DRB Application No.: 10DRB-70178

Project # 1008089

Project Name: *Vista De La Luz & La Luz Del Oeste*

**DRB Comments**

**SKETCH PLAT**  
 LOTS 61-A-P1, 62-A-P1, BLOCK A,  
 AND TRACT G-1, VISTA DE LA LUZ;  
 TRACTS J-1-A AND K-1, LA LUZ DEL OESTE UNIT 4

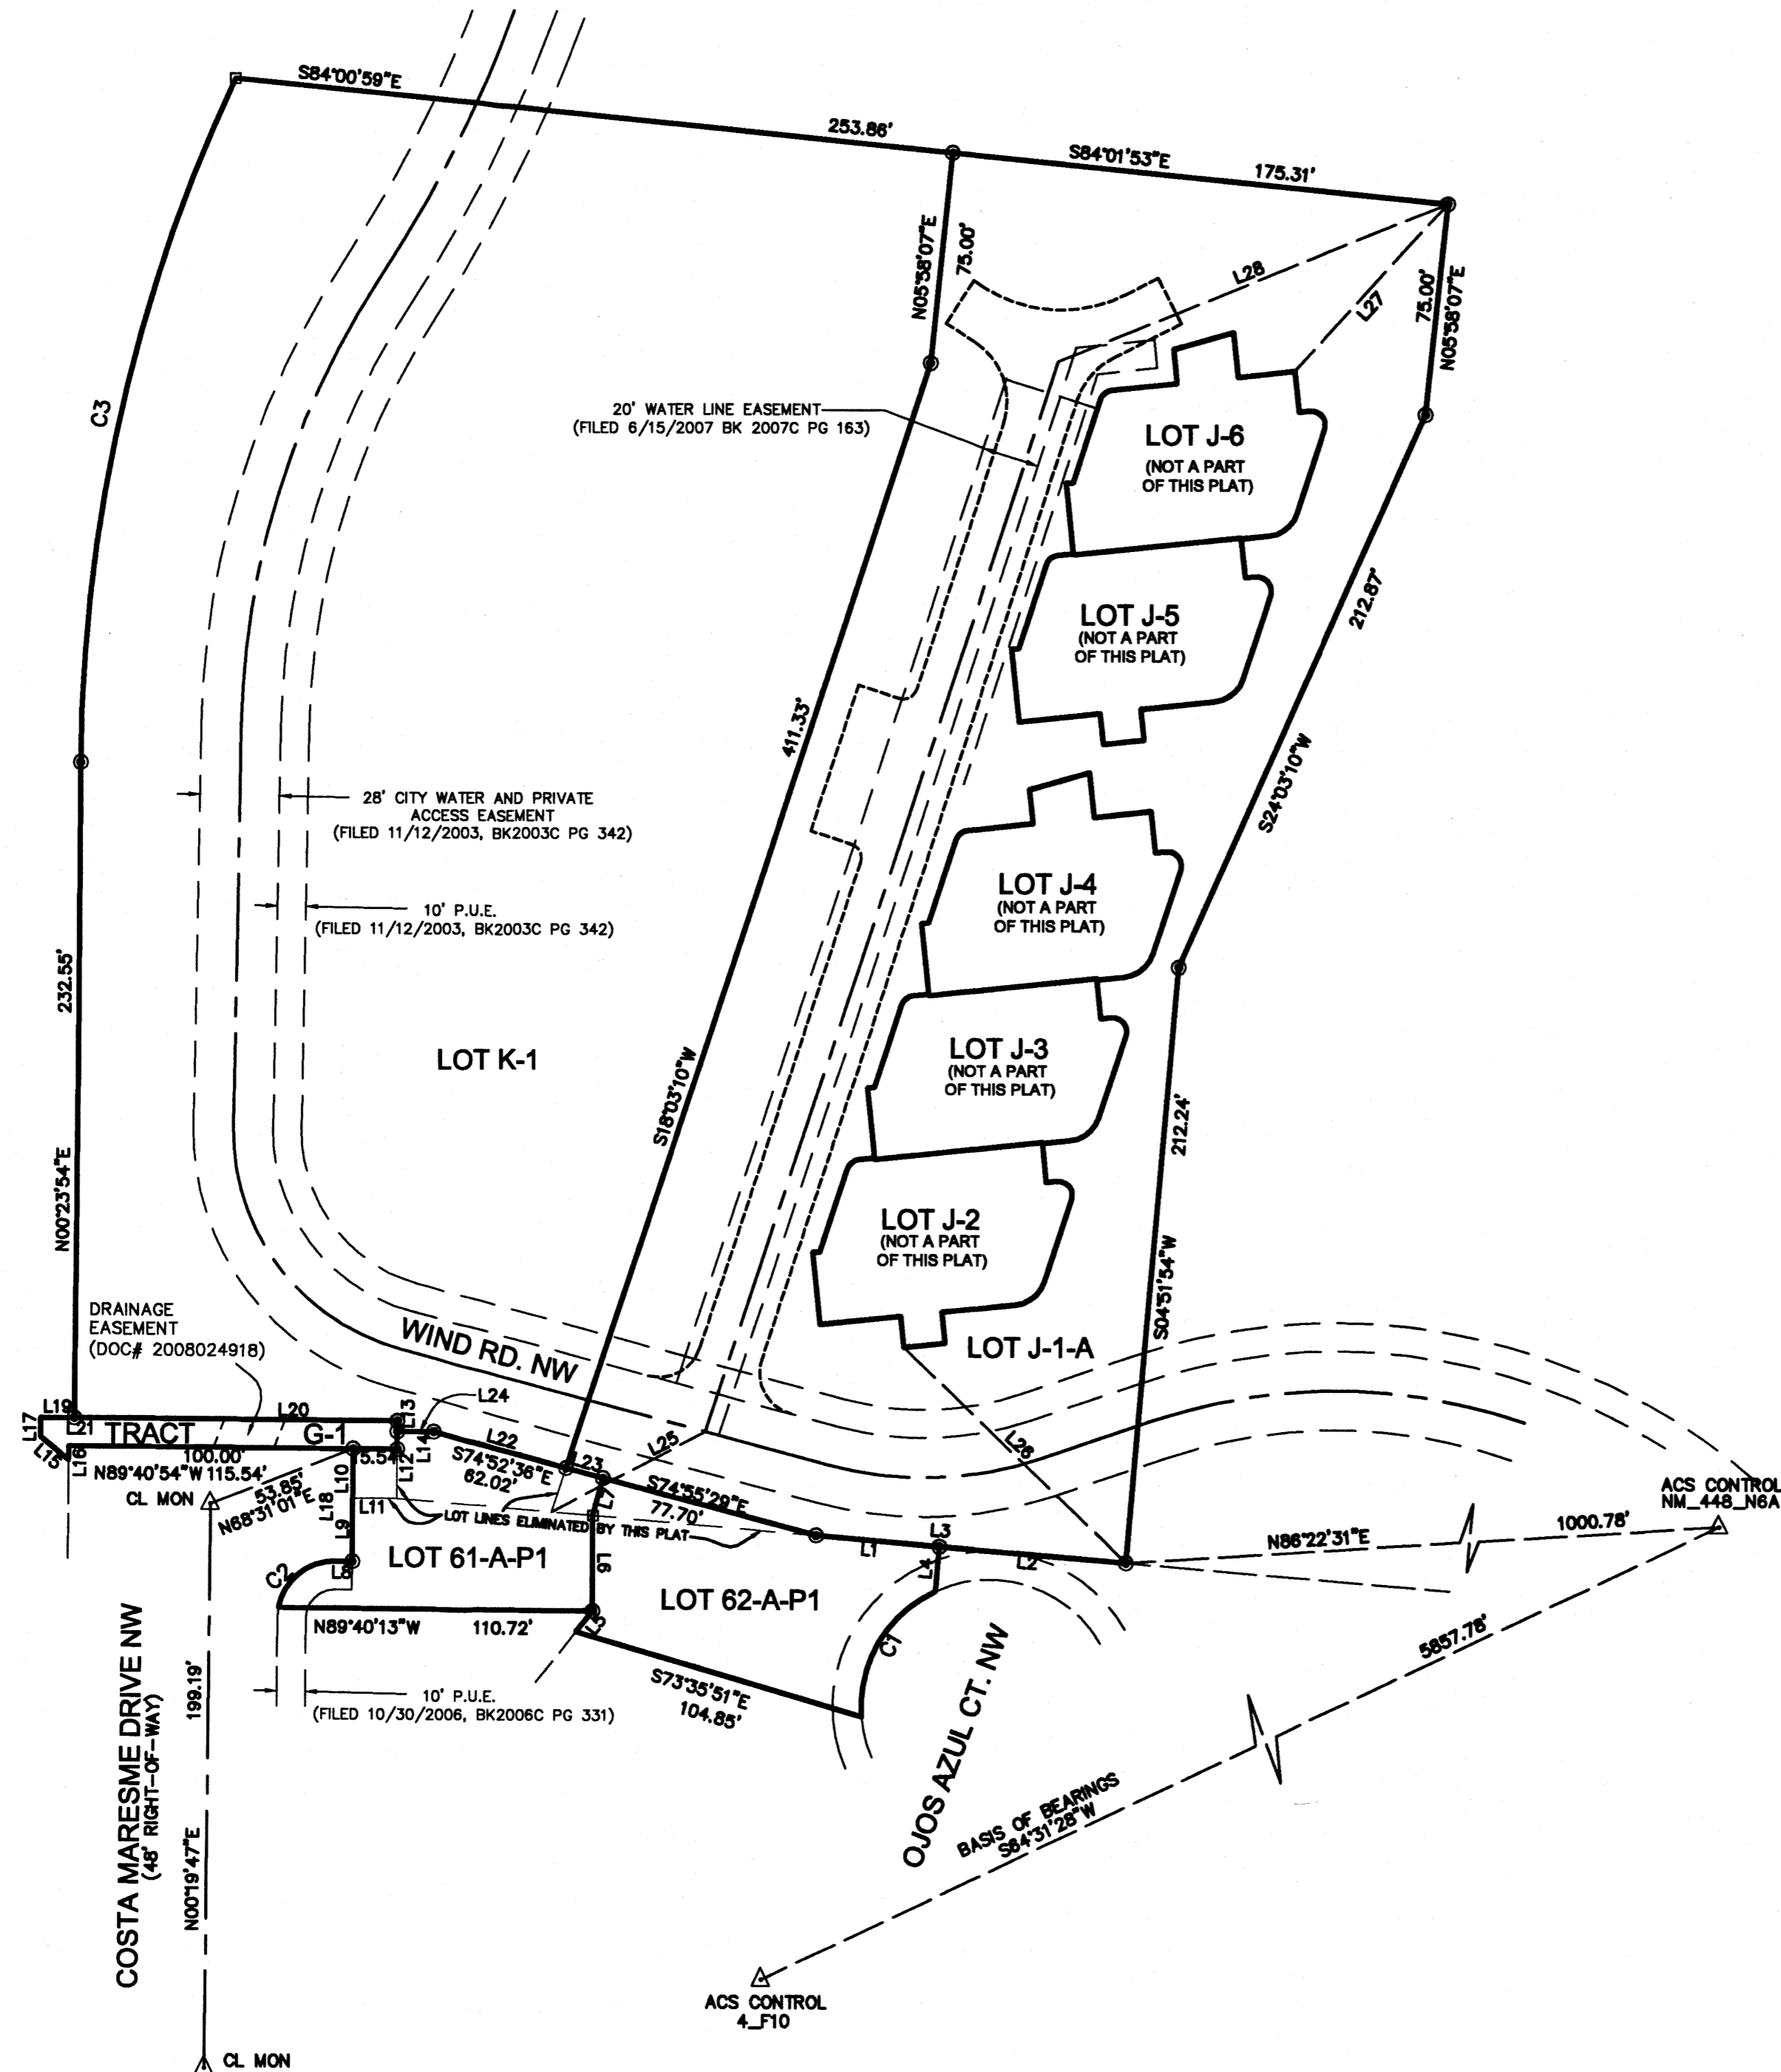
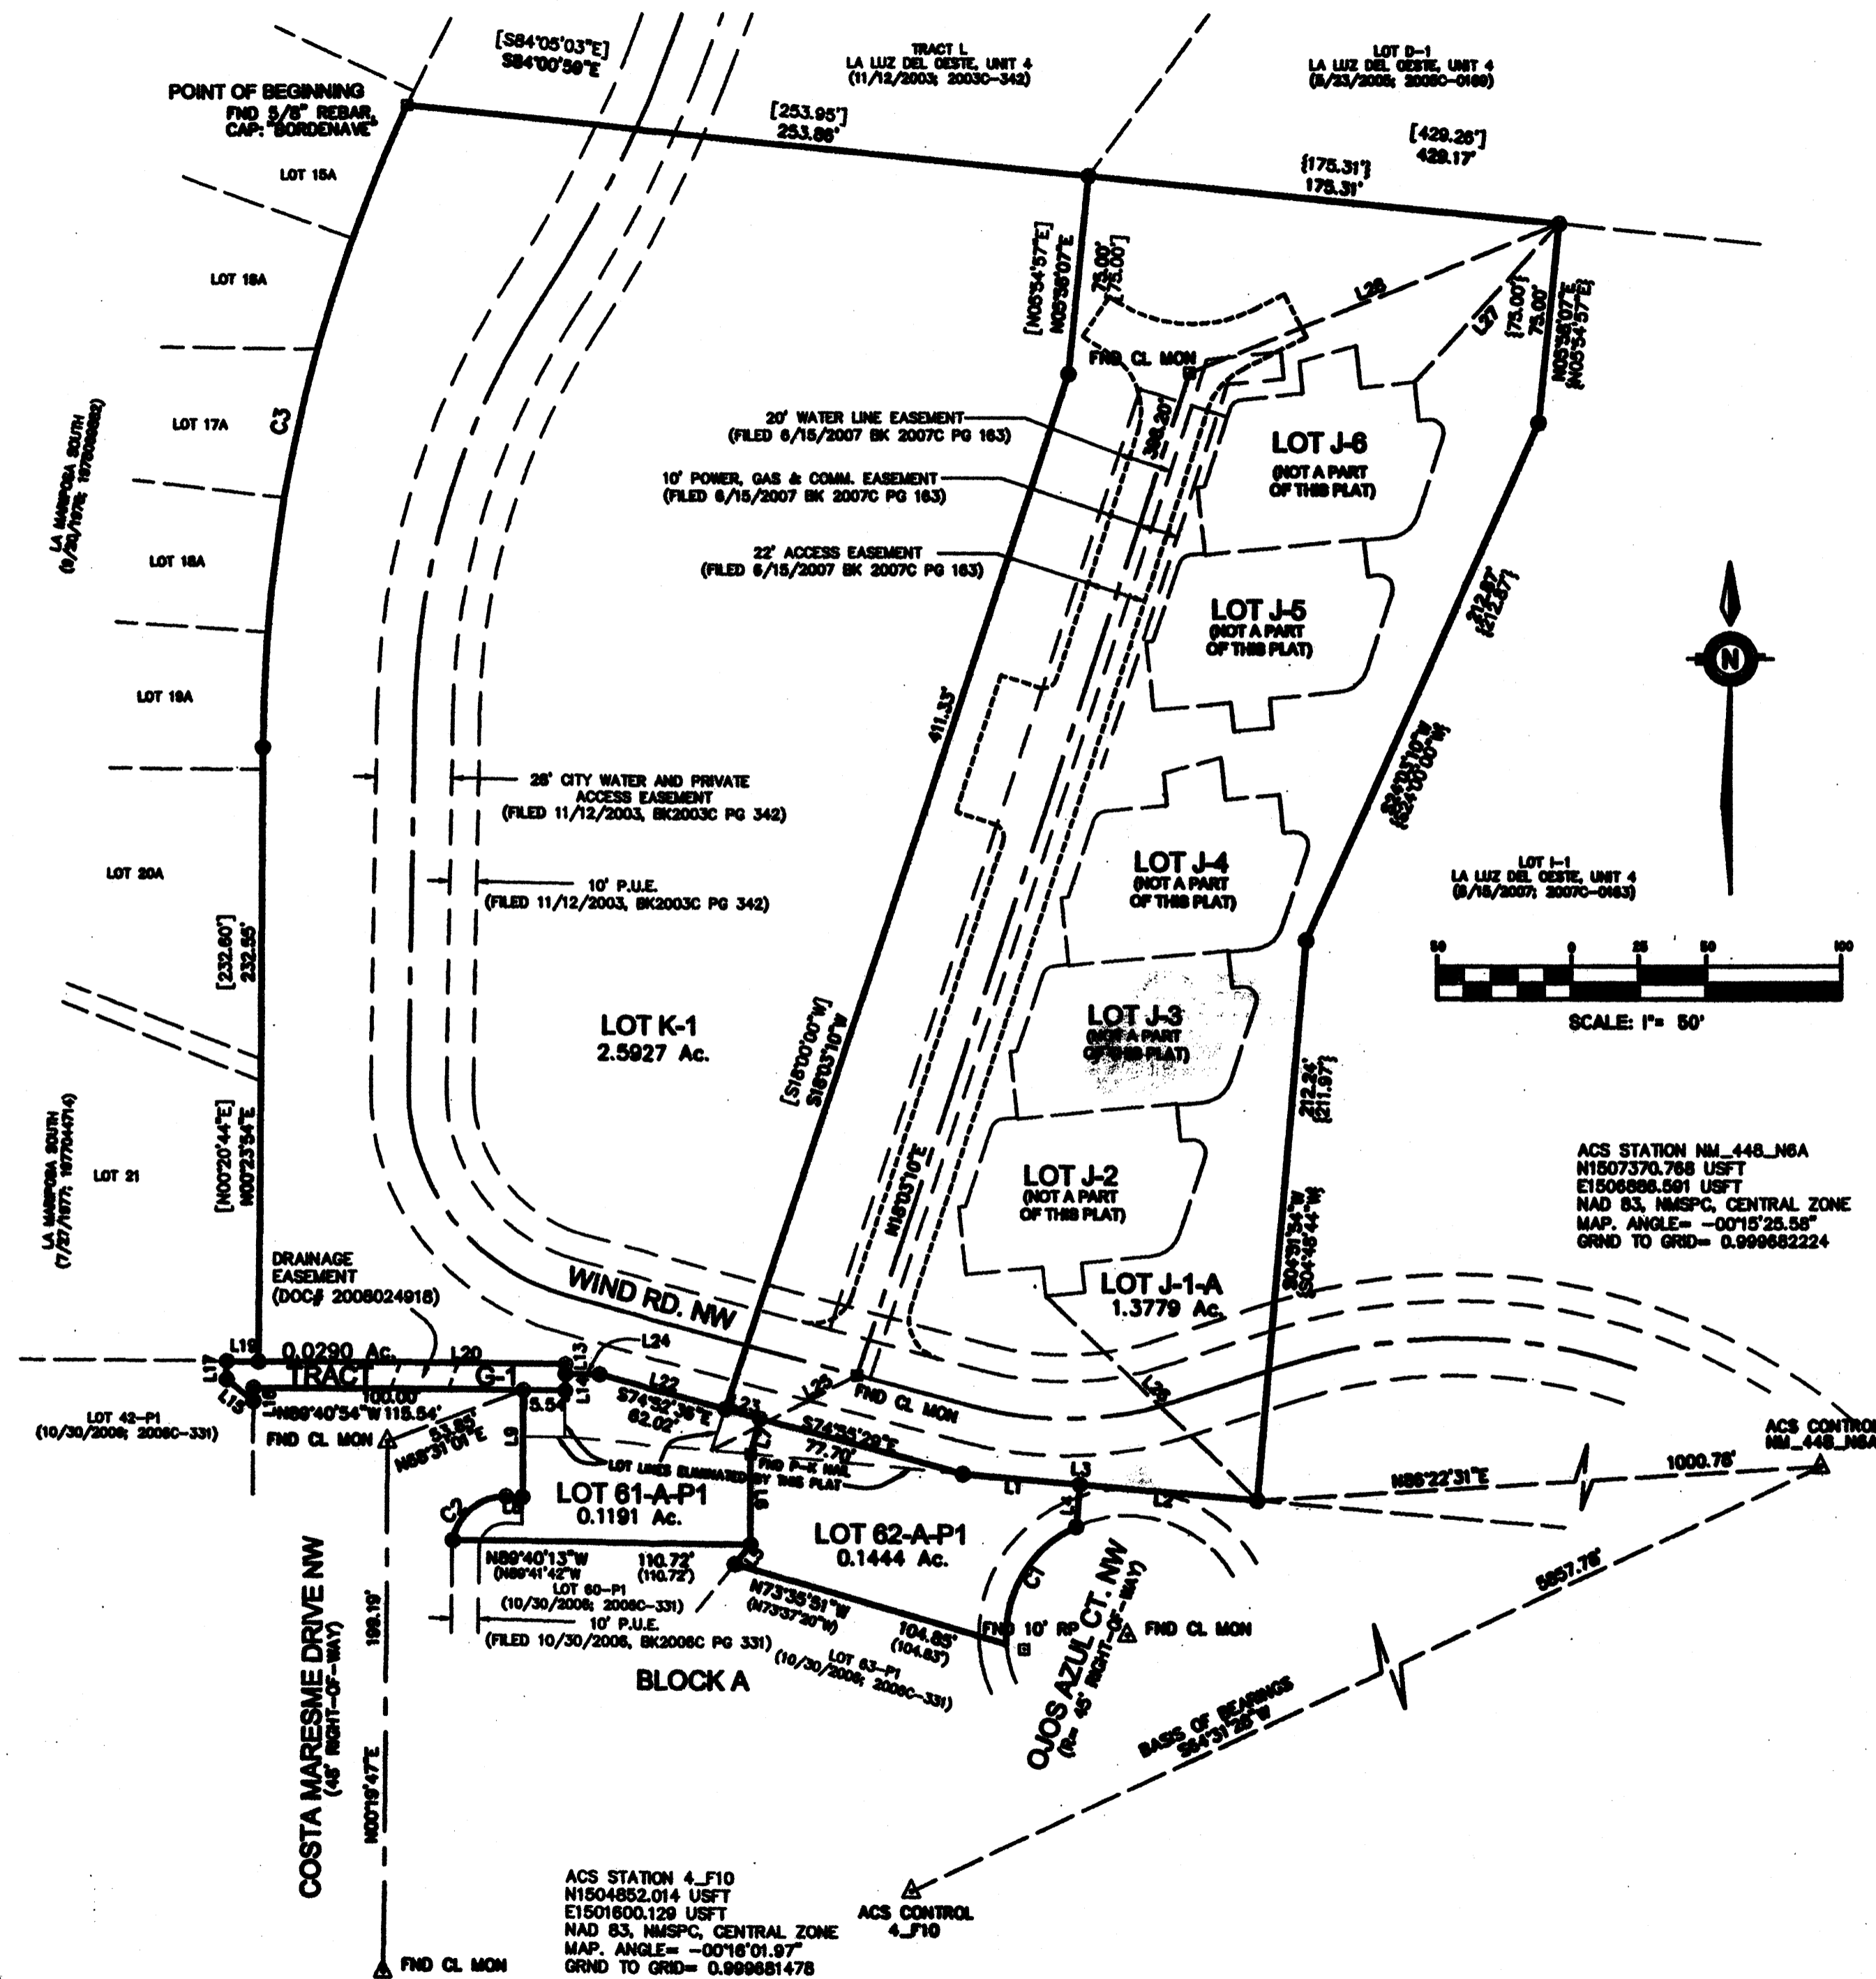
A solar access note consistent with the Subdivision Ordinance § 14-14-4-7 is needed, specific to the type of request: i.e. replace the words "REQUESTED FINAL ACTION" with the words "THIS PLAT" and delete the words "OR SITE DEVELOPMENT PLAN FOR SUBDIVISION" at the end of the note.

The respective site development plans (Vista = 1004675/ Oeste = 1002743) need to be amended (could potentially be done administratively). Is there an approved preliminary plat for the next phase of La Luz del Oeste? If so, that would need to be amended as well.
